Arun District Council
Arun Civic Centre
Maltravers Road
Littlehampton
West Sussex BN17 5LF
Planning & Building Control General Enquiries
Tel: (01903) 737756 Fax: (01903) 730442
Dx: 57406 Littlehampton
Minicom: 01903 732765
e-mail: planning@arun.gov.uk
website: www.arun.gov.uk/planning

Application No: CM/26/22/DOC
Site Address: Wren Cottage Horsemere Green Lane Clipping BN17 5QZ
Description of works: Approval of details reserved by condition imposed under CM/70/21/PL relating to conditions 3-Construction Management Plan, 5-Landscape Scheme, 15-renewable energy or low carbon energy sources and 17-schedule of materials and finishes.

Thank you for your internet representation made on 1st July 2022 which has been recorded as an objection with the comments as follows:

Drawing No.
6099-WLA-XX-ZZ-DR-A-0002

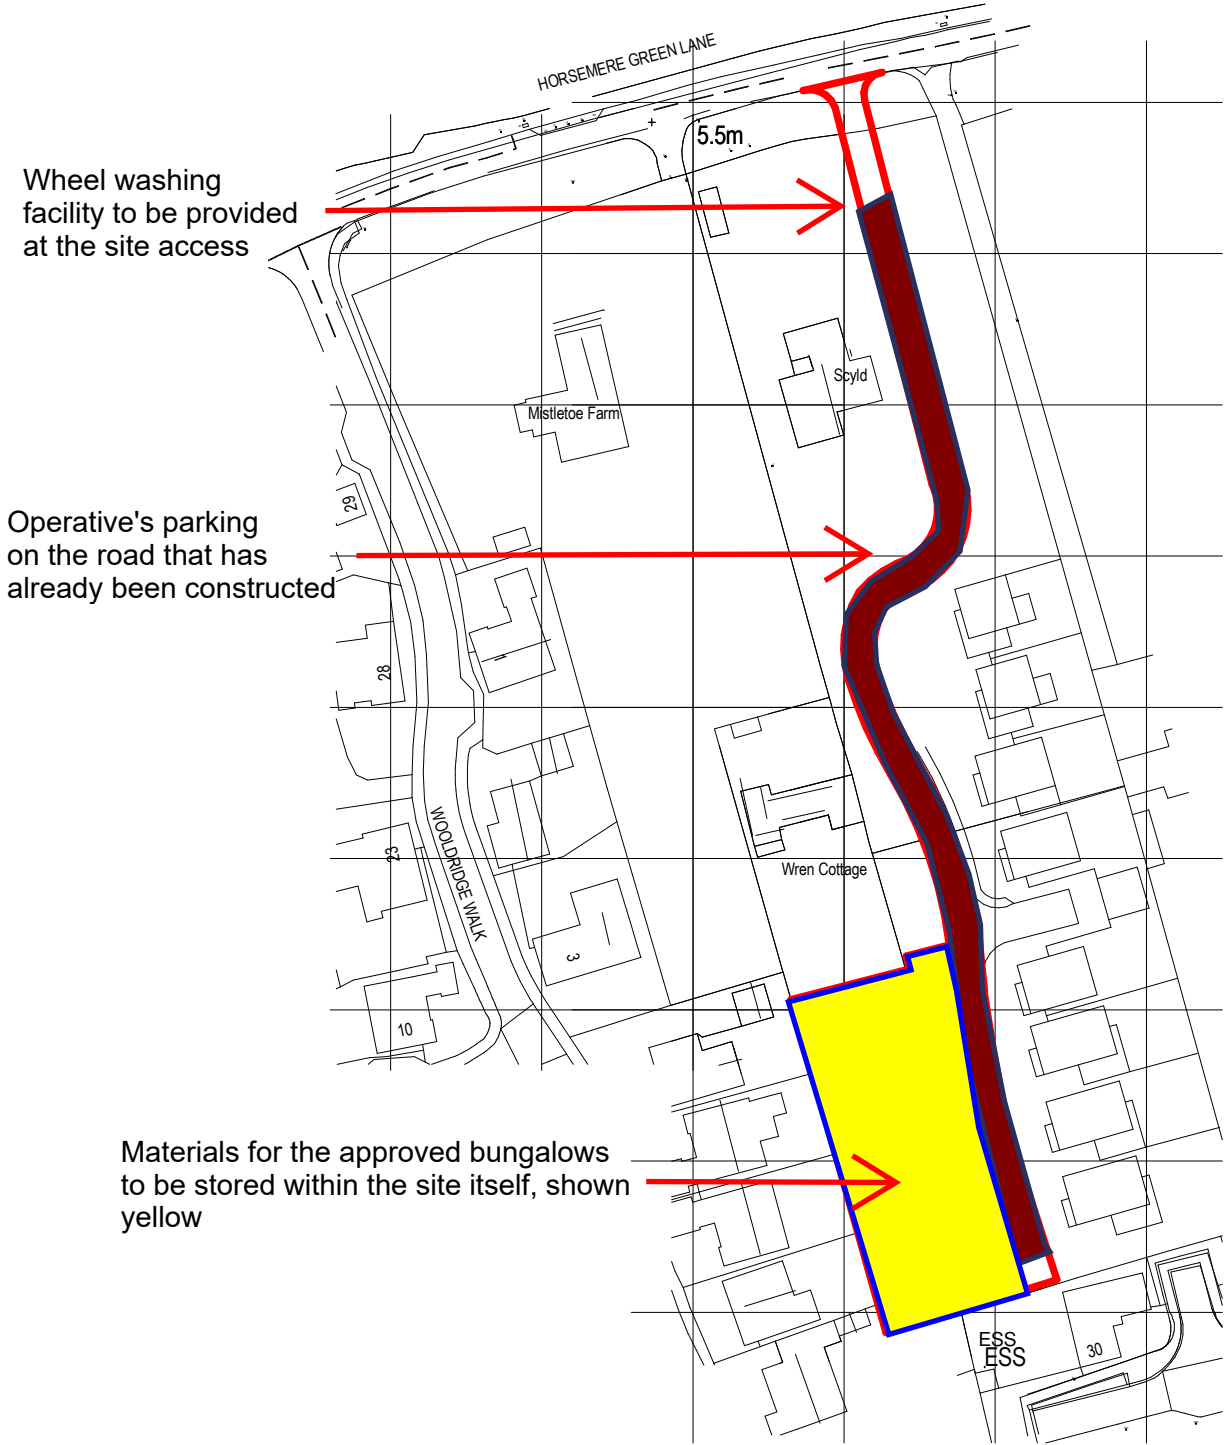
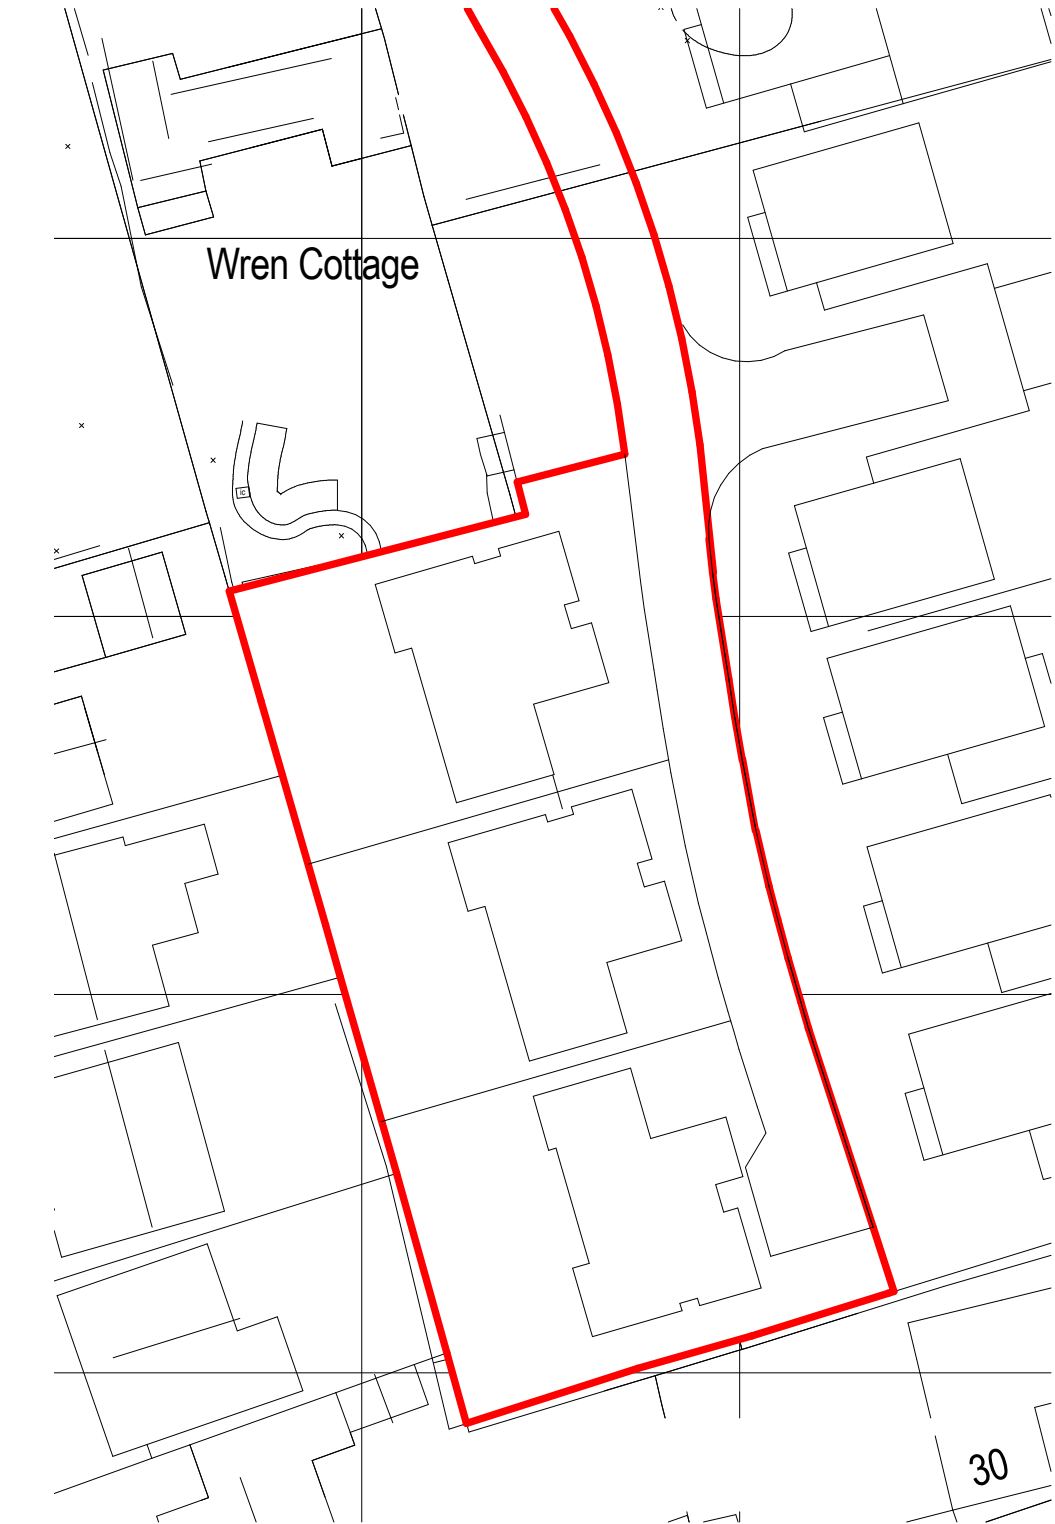
It is particularly disturbing that a resident of Wooldridge Walk is disputing the boundary as drawn on the plans and this matter requires resolution before anything proceeds.
